Subject: Environment Agency Response to: LU/223/18/PL

The proposal has been reviewed and I enclose the Environment Agency's comments on:
36 - 38 Surrey Street Littlehampton BN17 5BH

**CONVERSION OF BASEMENT & GROUND FLOOR FROM BOOKSHOP TO 3NO.
HOLIDAY LETS.**

36 - 38 SURREY STREET, LITTLEHAMPTON, BN17 5BH.

Proposed Floor Plans

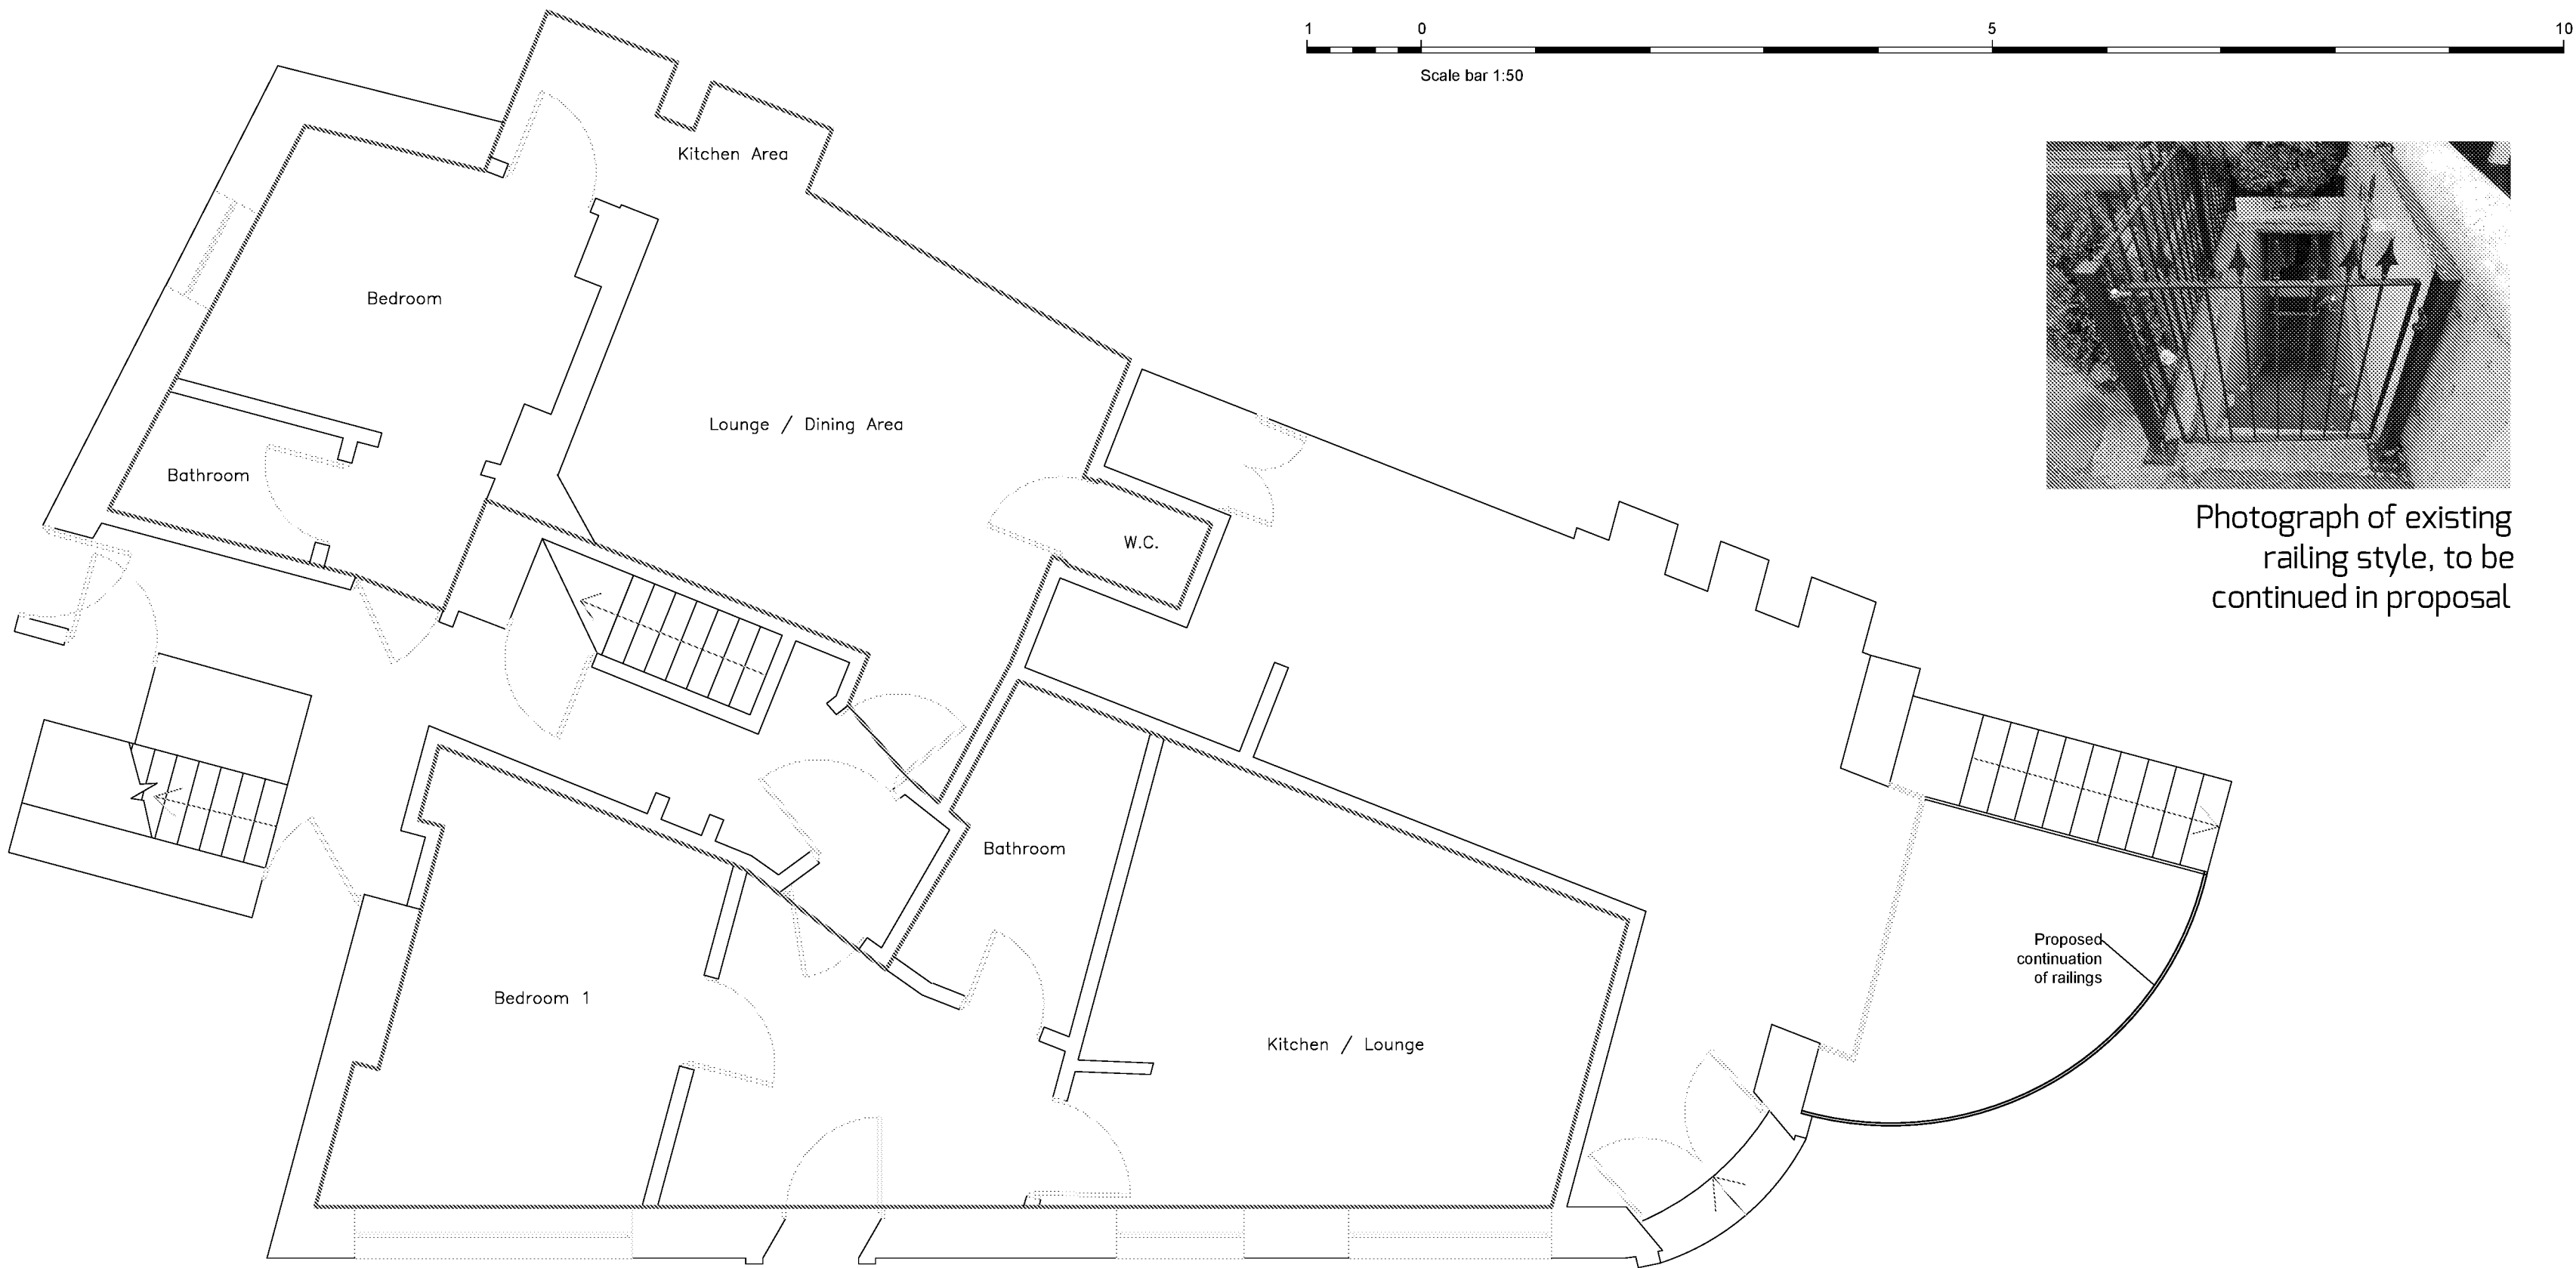
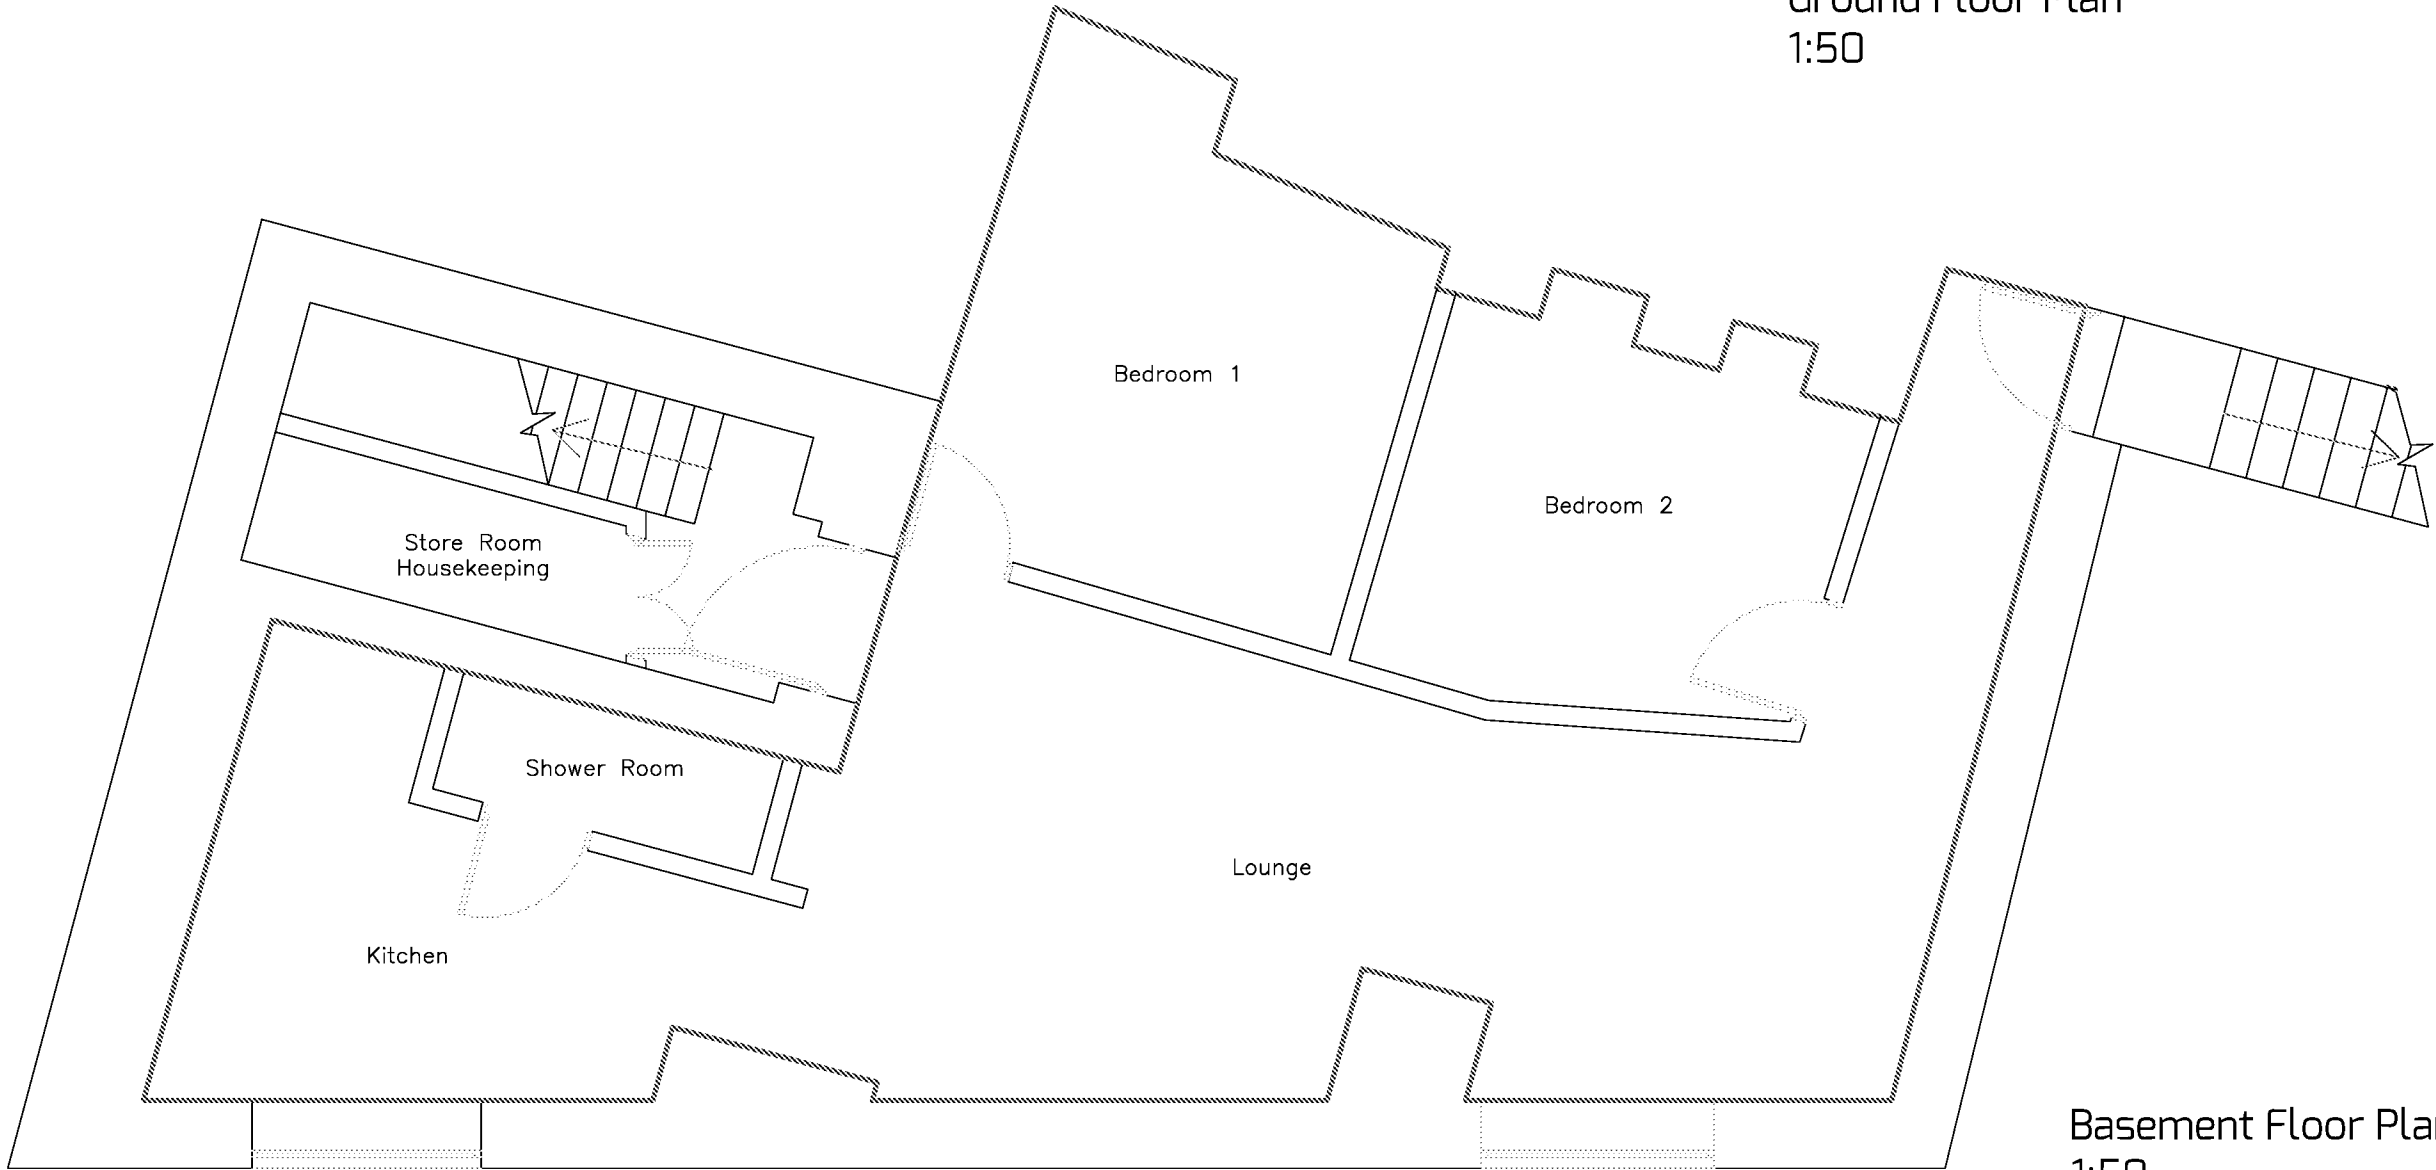
The development of proposing a **basement** holiday dwelling, is classed as “highly vulnerable” in accordance with Table 2 (Flood Risk Vulnerability Classification) of the PPG for Flood Risk and Coastal Change. Tables 1 and 3 of the PPG make it clear that this type of development is not compatible with this Flood Zone, and therefore should not be permitted.

We recommend the removal of all habitable rooms from the basement.

The approximate existing flood level for the site is 3.8mAOD, and predicted (2115) is approximate 5.0mAOD. No finished floor levels have been provided, and therefore no suitable mitigation measures are proposed.
